# CITY OF ALBUQUERQUE

June 26, 2015

**Re: Winrock Section 2 Grading and Drainage Plan**  
**Engineer's Stamp Date 3-7-15**  
**Drainage file number (J19D058C)**

DATE	03/06/15	SHEET	X
SCALE	1"=100'	C102	XX

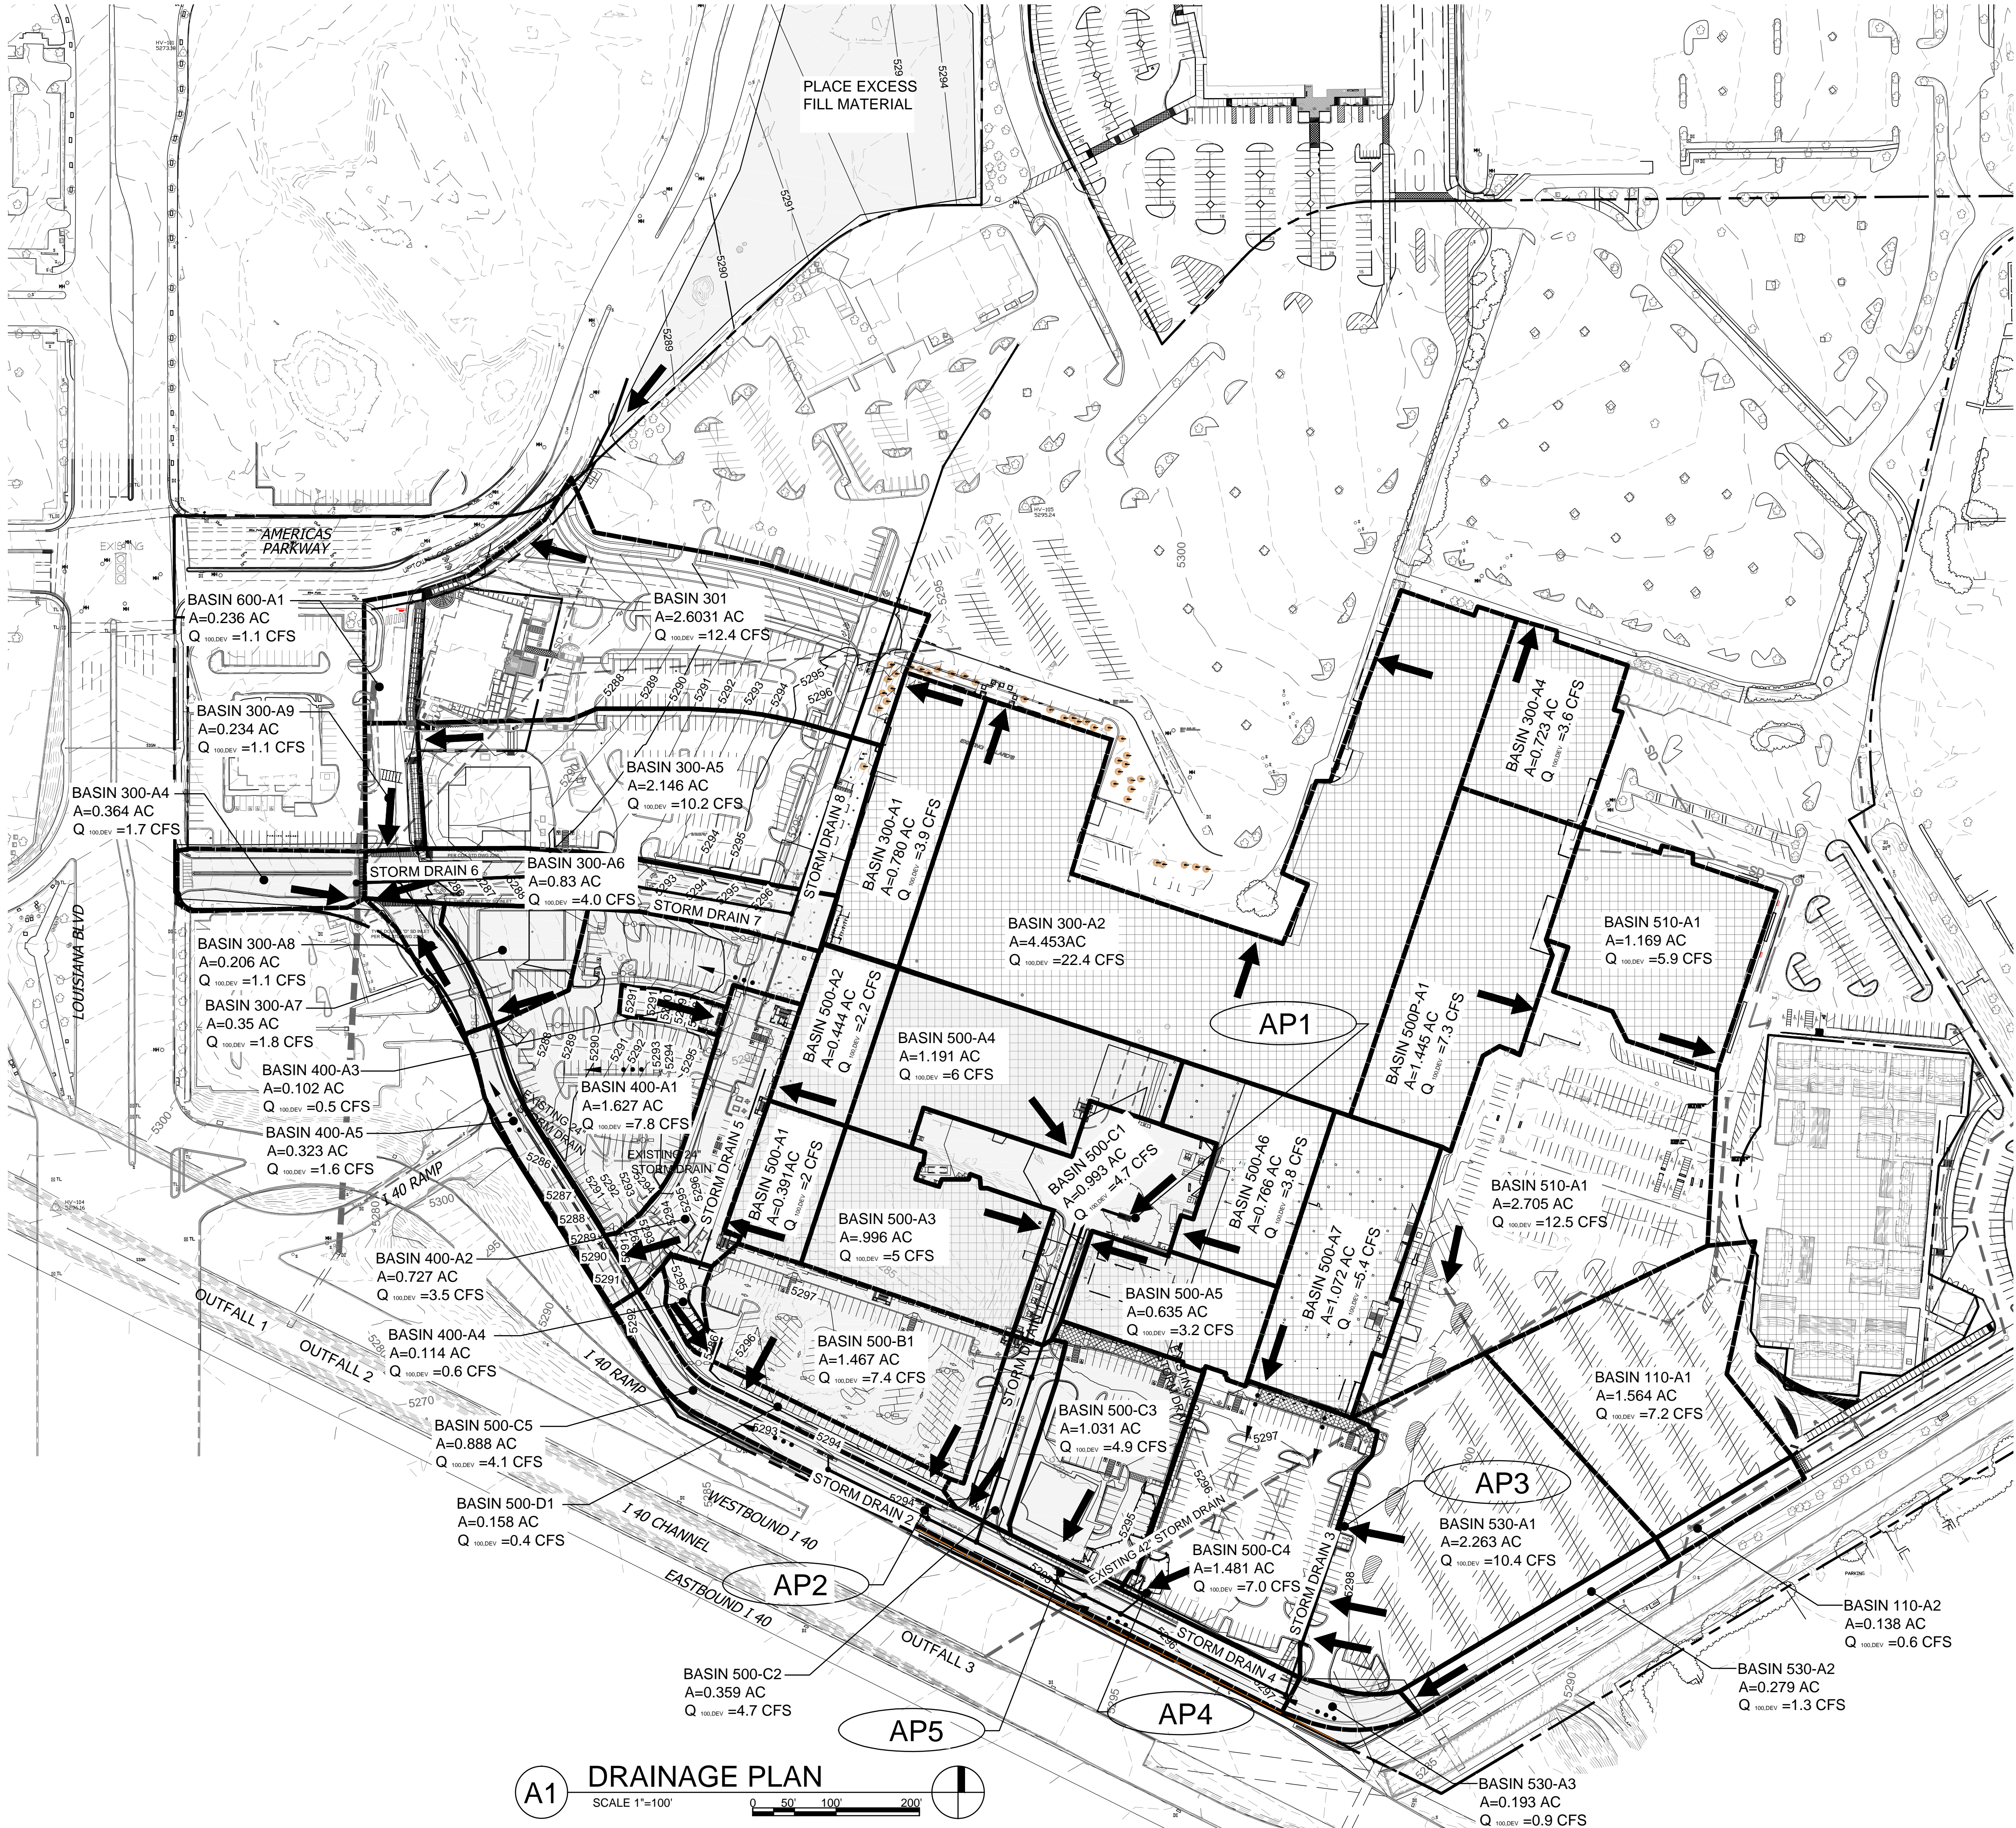
2. Label/show the location of the parking structure.
3. Basins 500-A1 and 500-A2 are 400 basins in the DMP Isaacson and Arfman 2015 (DMP). These flows appear to be directly connected to the storm drain, which does not allow for capture of the first flush. Perhaps the roof drains should daylight into the parking area, then drain to the landscape area where they could be captured in a perched grate.

PROJECT TITLE	WINROCK SECTION 2
PROJECT MANAGER	SCOTT EDDINGS P.E.
JOB NO.	R303699.01
DRAWN BY:	KLS
SHEET TITLE	GRADING PLAN

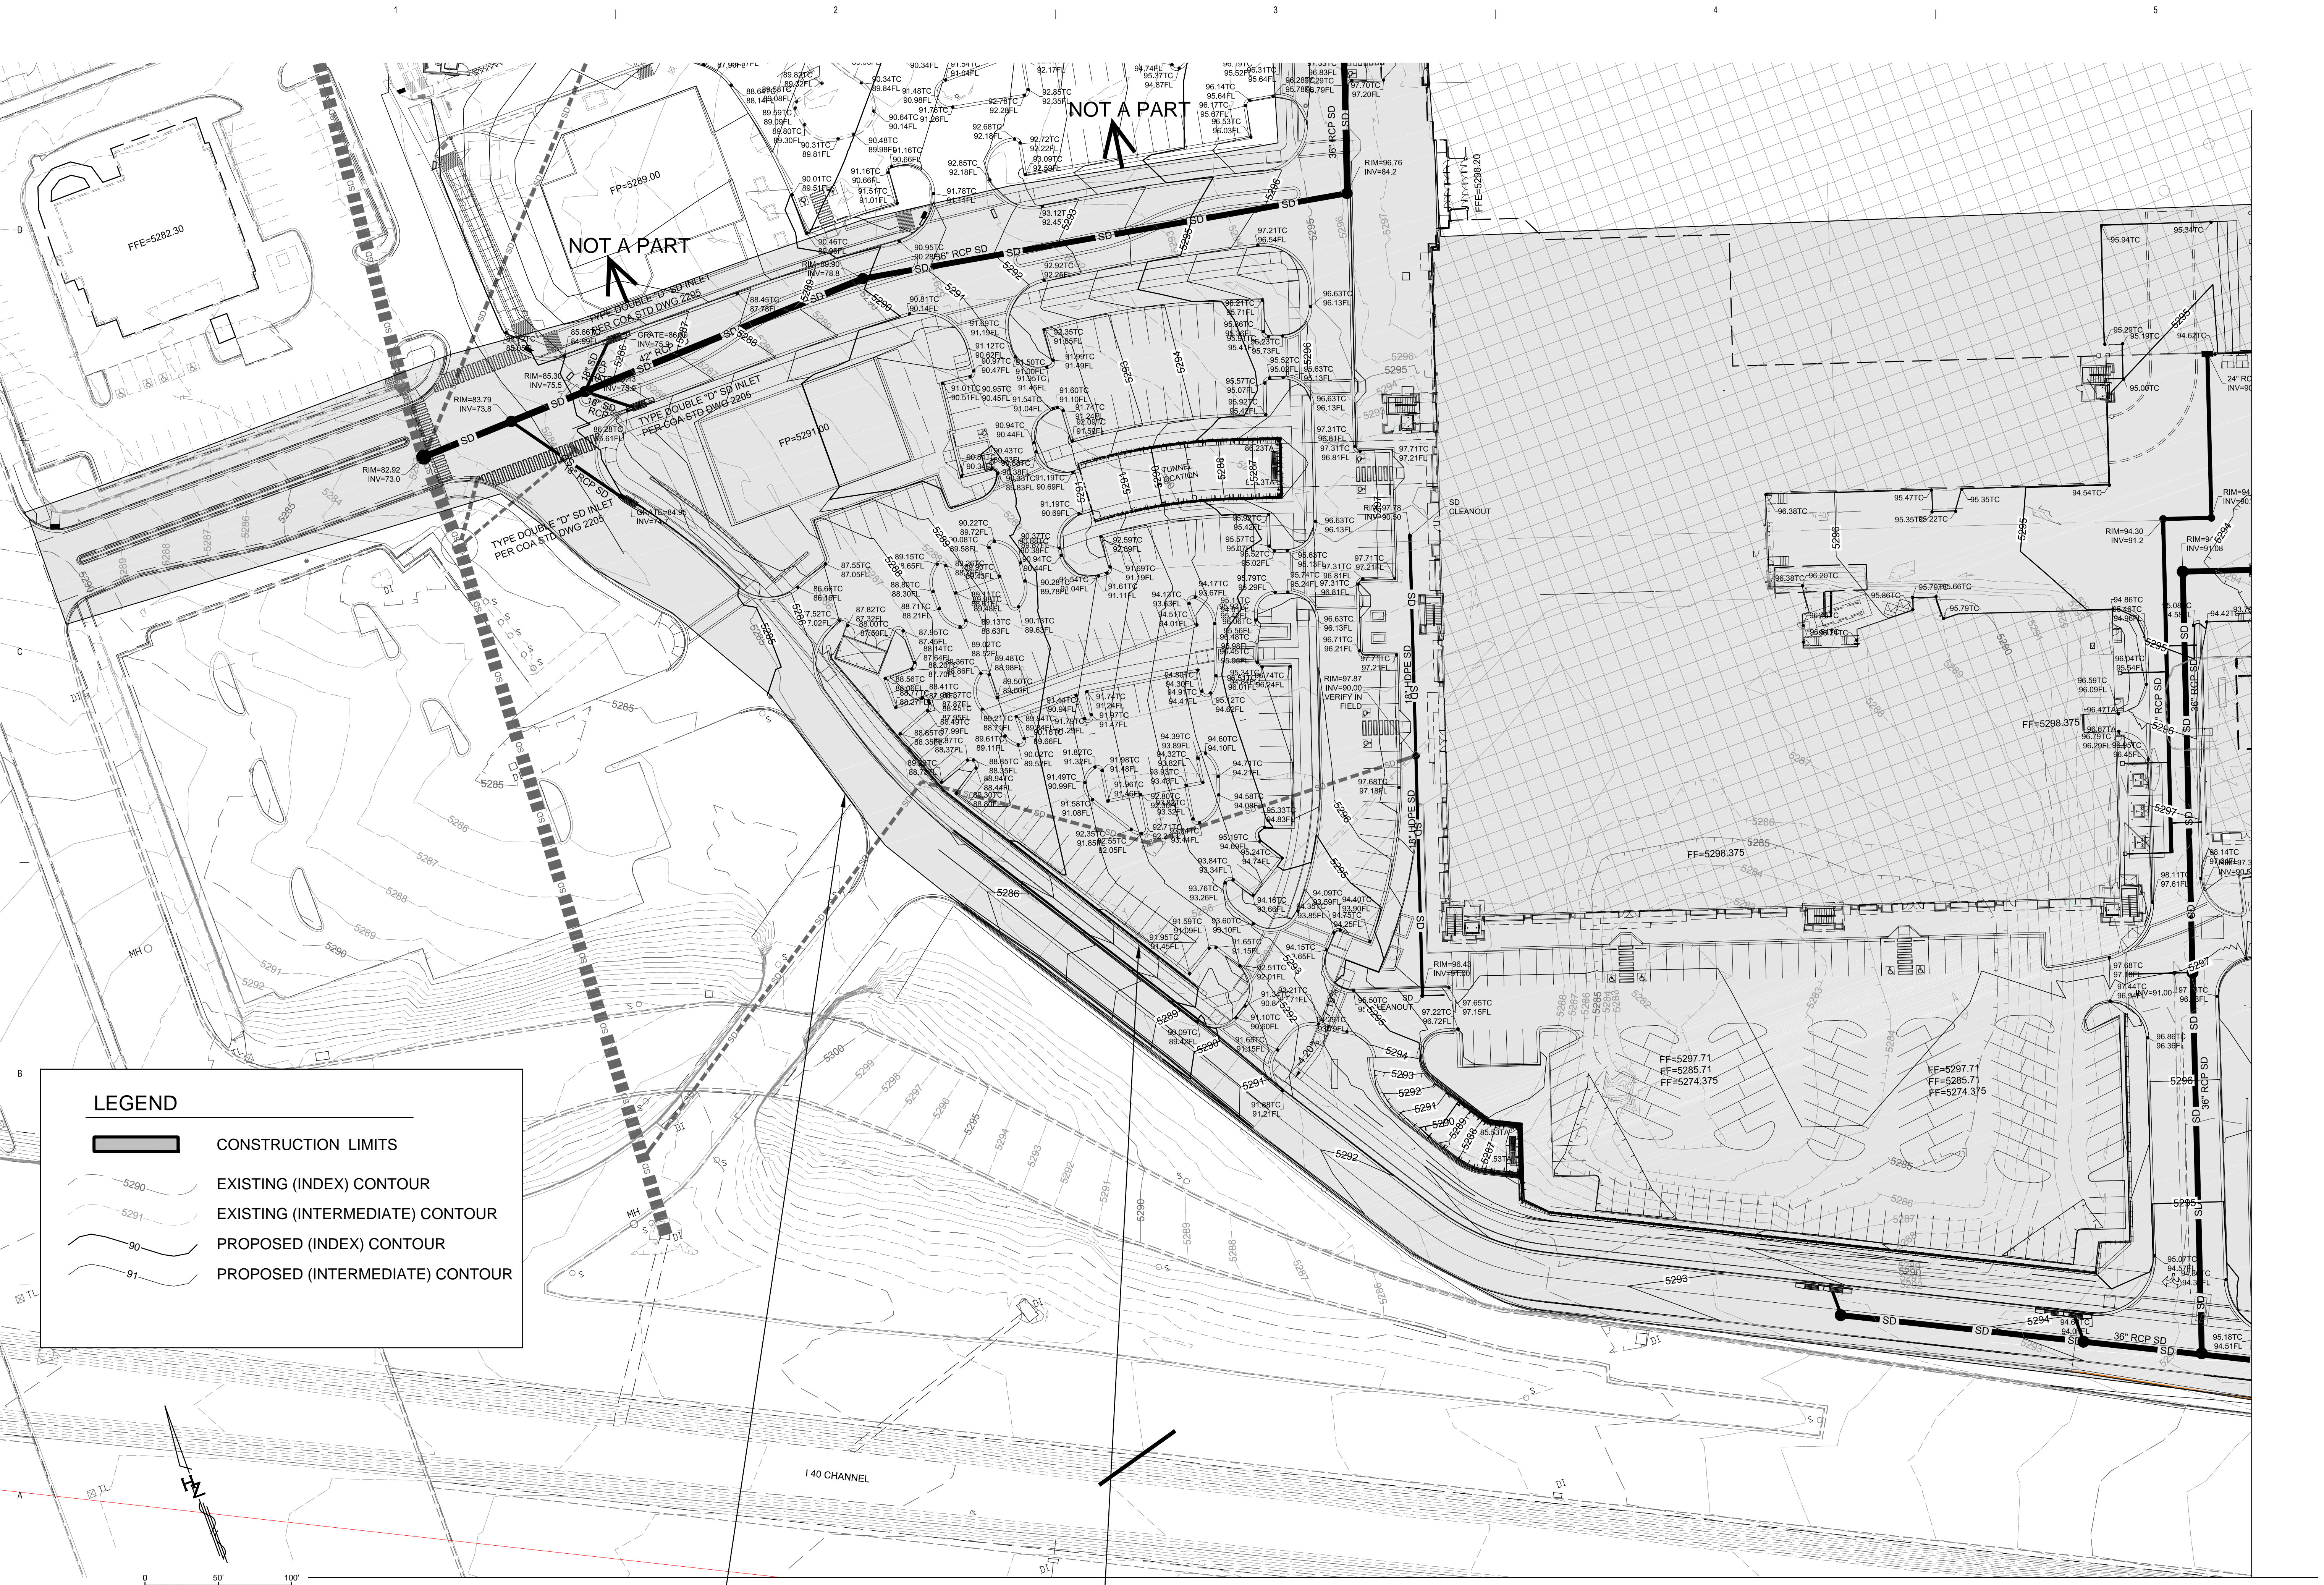
1. The information sheet states this plan is for the parking structure, but it appears to have a larger scope. The narrative states it is for Section 2 and Section 4. Please clarify the buildings/structures this submittal is pertinent to. This will help with the Building Permit approval process. Out buildings could be called Pad1 and Pad2, etc...

9. How is the first flush captured from Basin 500-C5, 400-A5, Basin 530-A3, 530-A2 and 110-A2? Flows could be brought into the landscape area on the north side of the access way. A section would be beneficial.
10. The first flush pond is not obvious in Basin 500-D1.
11. Inlets in the ring road are shown on the north side only. Is this access way to be super-elevated? Proposed contours show a normal crown.
12. Storm drain 8 appears to extend past the shaded construction limits. Provide a buffer (white space) between the construction limits and the area where no work will occur on this plan.
13. Add a statement that an approved grading and drainage plan will be required for Building Permit approval on the out-lots.
